Application for a non-material amendment following a grant of planning permission, Town and Country Planning Act 1990

Non material amendment to previous permission 2023/93480 for erection of ground floor and first floor extensions and alterations to convert two dwellings into one dwelling

65-67, Huddersfield Road, Shelley, Huddersfield, HD8 8HG

Application Number: 2025/92956

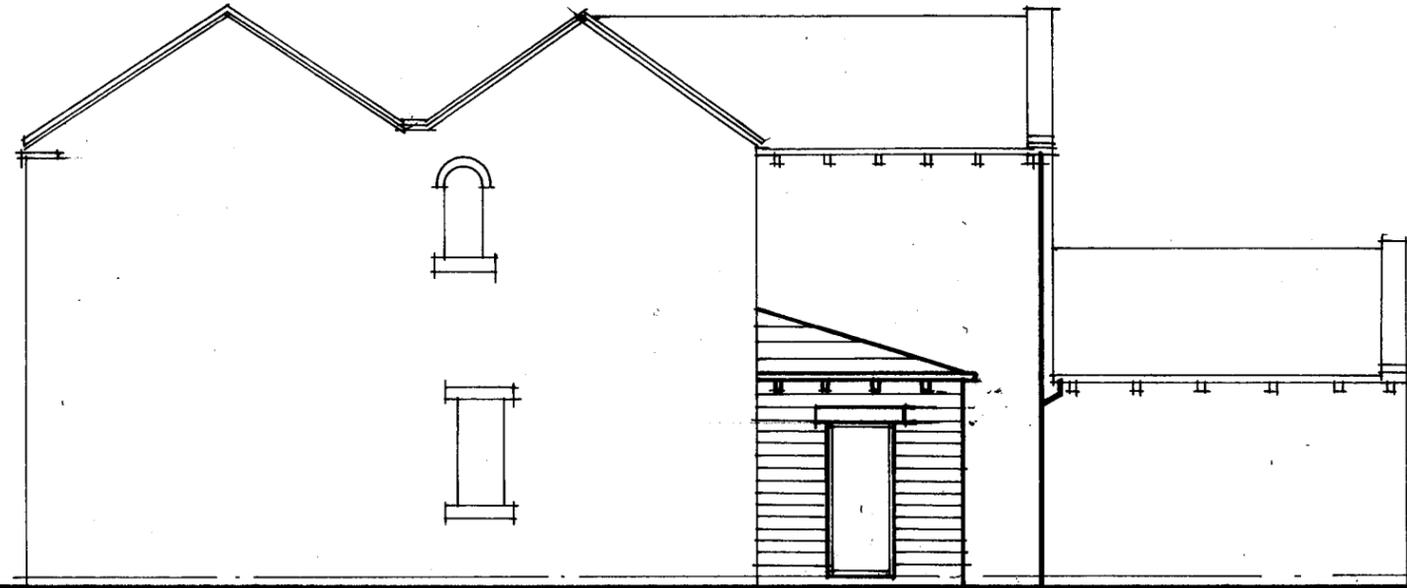
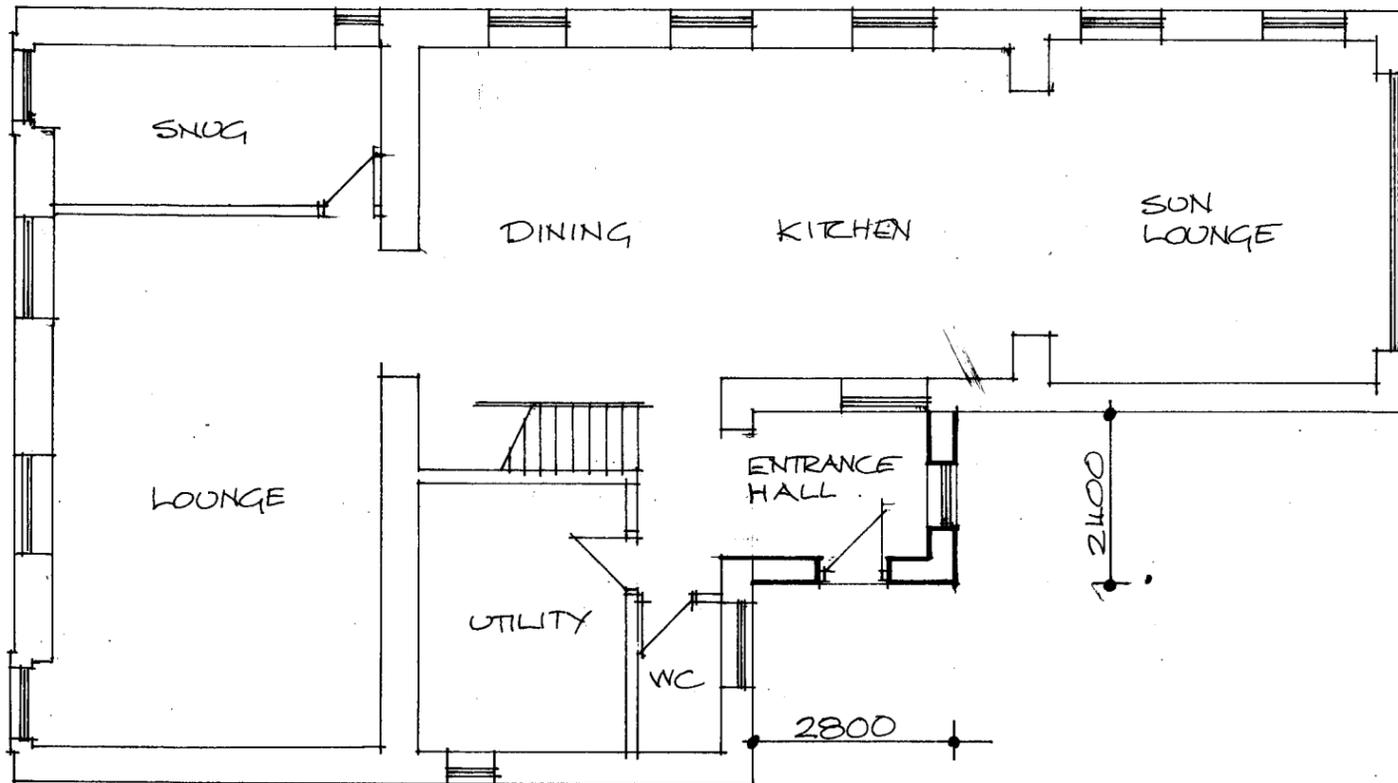
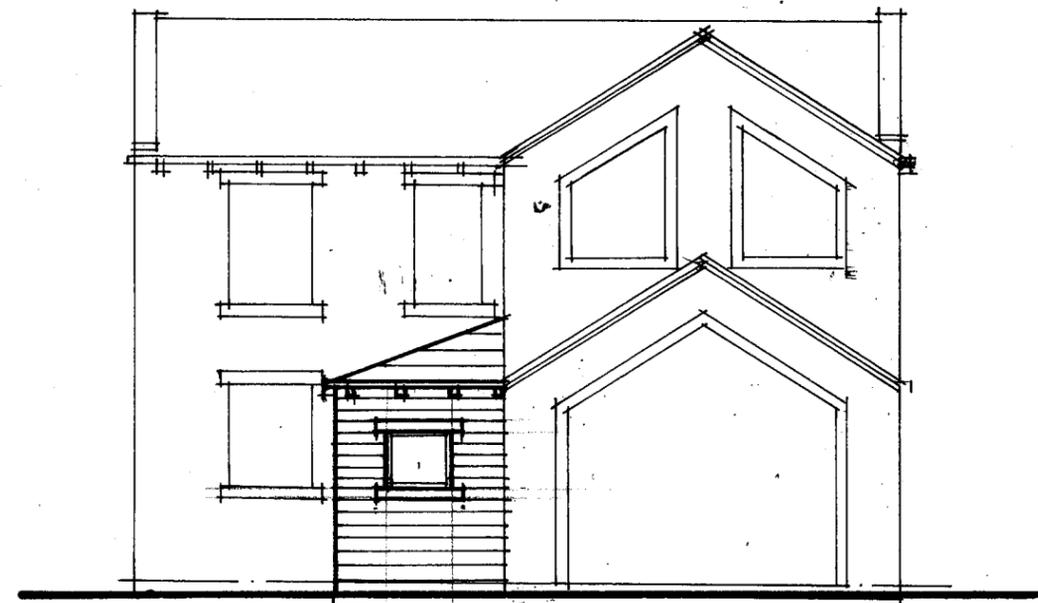
The amendment sought to replace the rear extension canopy with a single storey extension to form a porch as shown on drawing number HRS/09 is not considered appropriate to be regarded as a non-material amendment to the previous planning approval 2023/93480. The applicant is therefore advised to submit an application to vary Condition 2 (approved plans) under a Section 73 (variation of conditions) application for the proposed amendment.
